STATE OF NORTH CAROLINA  
DEPARTMENT OF TRANSPORTATION

December 10, 2019

Subject: **Modification Request for Section 401 Water Quality Certification and Neuse Riparian Buffer Authorization** for Interstate 40 Widening and Improvements from I-440/US 64 (Exit 301) to just north of SR 1525 (Cornwallis Road), including improvements to NC 42 and SR 1010 (Cleveland Road) in Wake and Johnston Counties, Federal Aid Project No. IMNHF-040-4(139)301; TIPS I-5111 and I-4739, Division 5; Debit \$570 from WBS Element 42346.3.1.

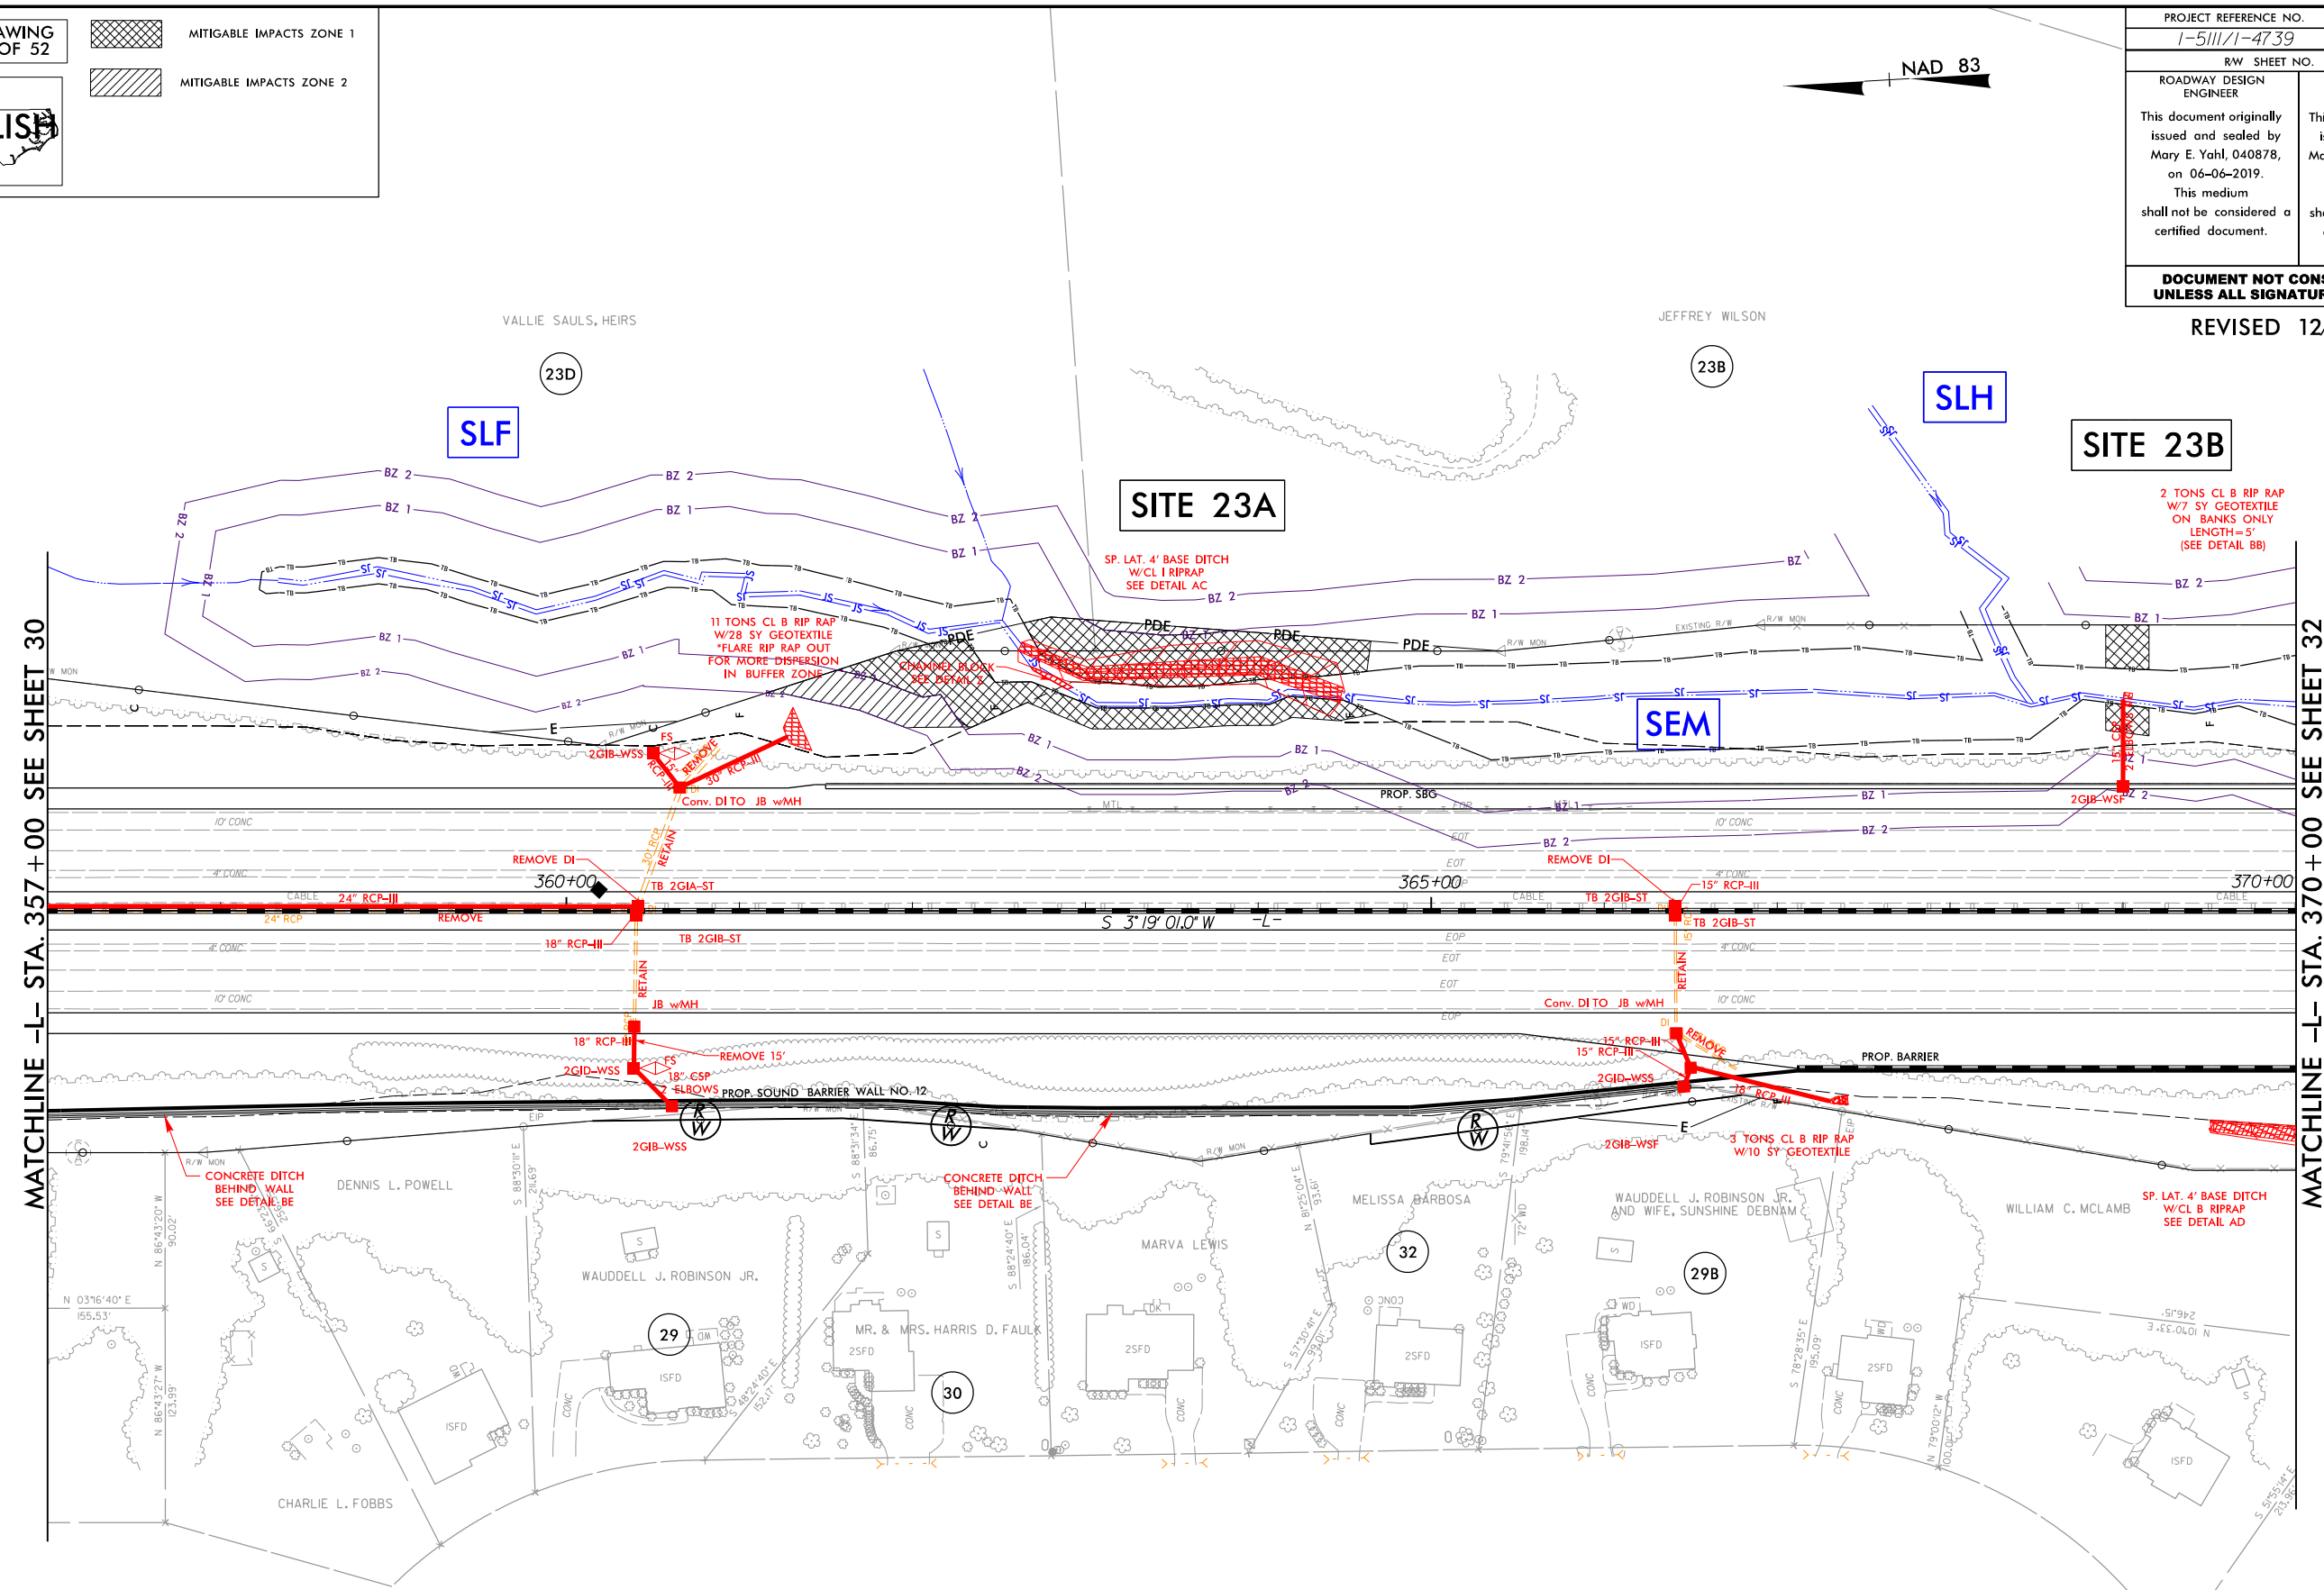
- Buffer drawing 1 of 52: titlesheet
- Buffer drawing 23 of 52: plansheet 31 reflecting revisions to Sites 23A and 23B
- Buffer drawing 24 of 52: plansheet 32 reflecting a revision to Sites 26A
- Buffer drawing 47 of 52: summary table
- Buffer drawing 51 of 52: summary table

- Site 23A: previous mitigable zone 1 impact total: 8,260 sqft; new mitigable zone 1 impact total: 10,192 sqft (difference of 1932 sqft)
- Site 23B: previous mitigable zone 1 impact total: 635 sqft; new mitigable zone 1 impact total: 1,037 sqft (difference of 402 sqft)
